From: Stuart Corbey
Sent: 09 April 2019 17:54
To: 'Holland Architecture'
Cc: Martyn White
Subject: RE: Rookery Cottage Y/13/19/HH

Further to our telephone conversation I would like to take this opportunity for you your client to review the design and significance of the design, scale and layout of development to this non-designated heritage asset. The buildings importance has been considered by Arun DC Historic and Listed buildings advisor - Martyn White.

PROPOSED ELEVATIONS AND SECTIONS

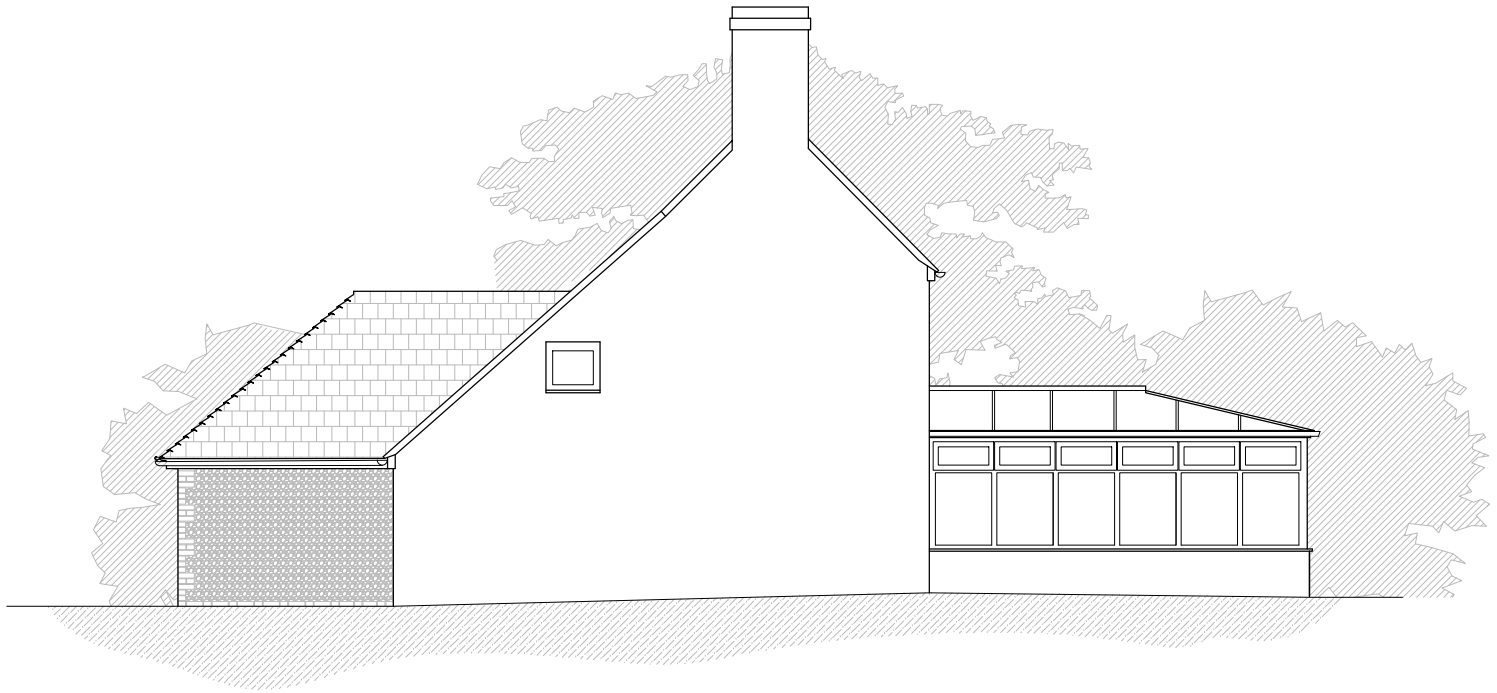
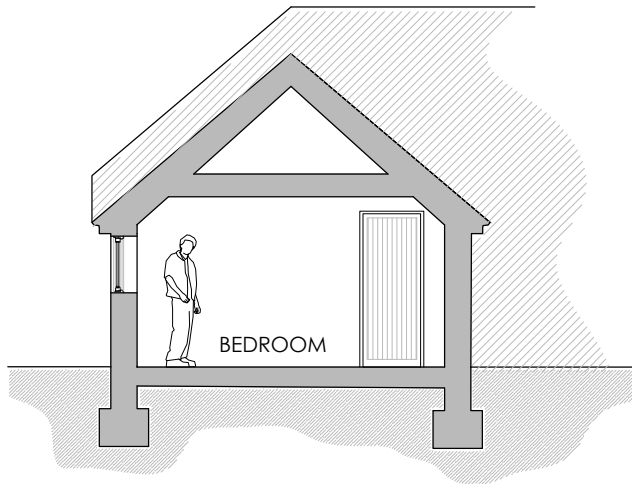
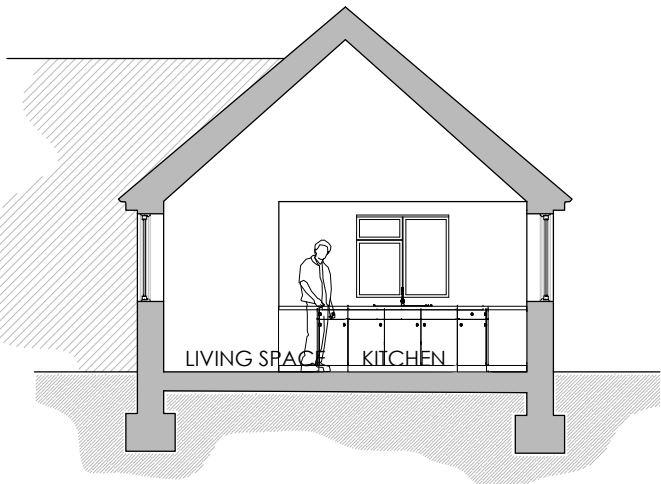
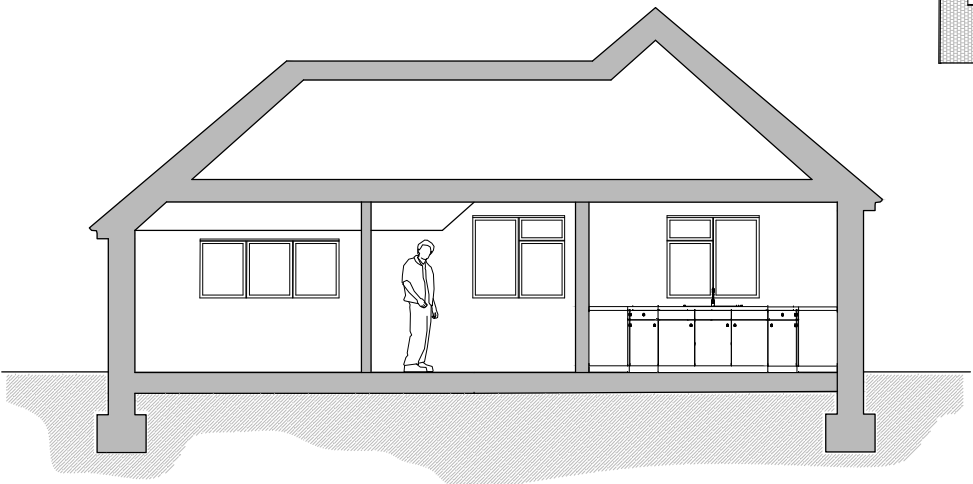
The officers consider the development fails to meet the above criteria. It fails to reflect the character and appearance, whilst the scale would not result in sympathetic addition to benefit the existing dwelling to its benefit. For the above reasons the officers have no choice but to refuse the current scheme.

We do believe the property is worthy of extending, and we invite you to withdraw the current application, and work with us to consider the above points and resubmit following further consideration.
